WEST SUSSEX COUNTY COUNCIL CONSULTATION

TO:	Arun District Council FAO: Michael Eastman
FROM:	WSCC - Highways Authority
DATE:	2 May 2019
LOCATION:	Land North of Felpham Charles Purley Way Felpham
SUBJECT:	Y/31/19/PL Removal of sport facilities originally approved under application Y/68/09 in order to retain this as a landscaped area.
DATE OF SITE VISIT:	02/05/2019
RECOMMENDATION:	Modification
S106 CONTRIBUTION TOTAL:	£ See below for breakdown.

Drawing Title:
CHANGING FACILITIES BUILDING
SITE LAYOUT

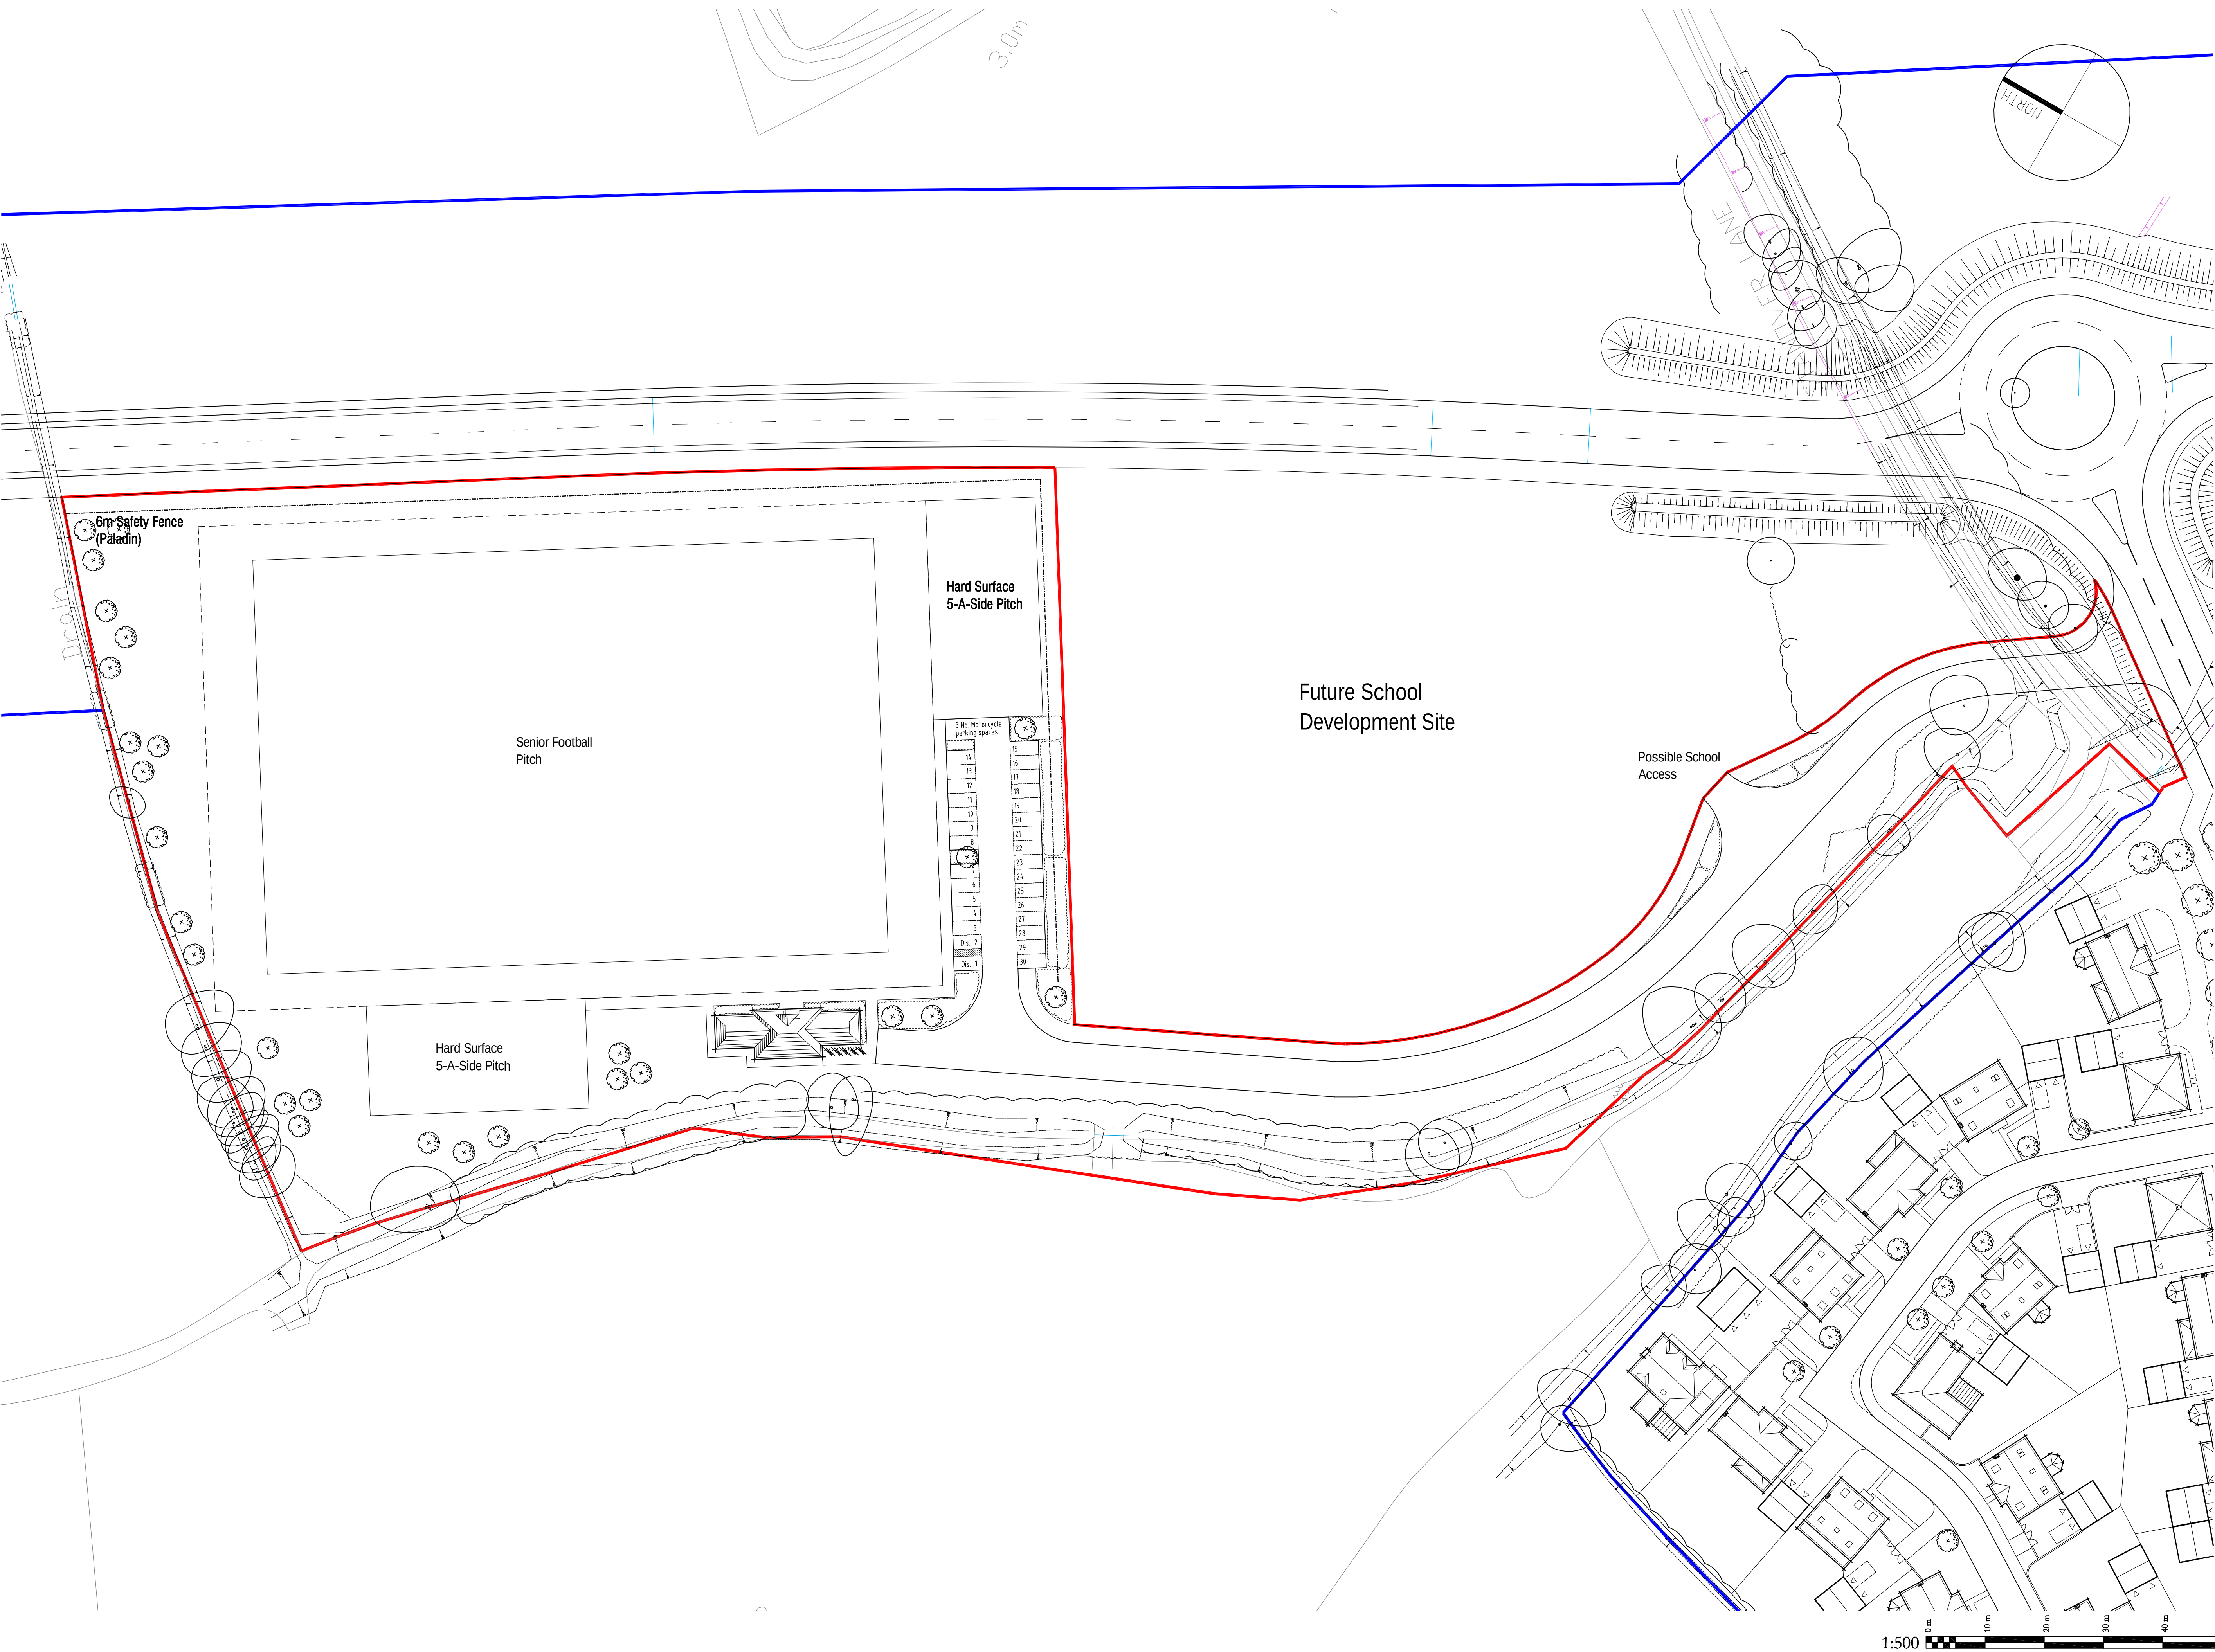
WSCC would like to see dropped kerbs included at the access, to the car park. Ideally this will continue over the other side which will provide a direct link into the 'entrance' of the landscaped area. It appears there is a gate, accessed from the road but there is no footway access as such.

The car park layout should consider access for all its users. The plan submitted shows it is bounded by a timber knee rail fence and an area of pedestrian tarmac provides a path along the left hand side of the car park. It is recommended this footpath is at least 2m in width and as it currently does not link to anywhere, this should be changed to provide a link from the parking area directly to the entrance gate.

As the landscaped area will not provide any hard surface it may be difficult for wheelchair users to have the opportunity to access this space safely. In our opinion the layout of the 'entrance gate' needs to provide appropriate surfacing for users of wheelchairs, mobility scooters, and walking aids to be able to enjoy the rural environment. Benches could also be considered.
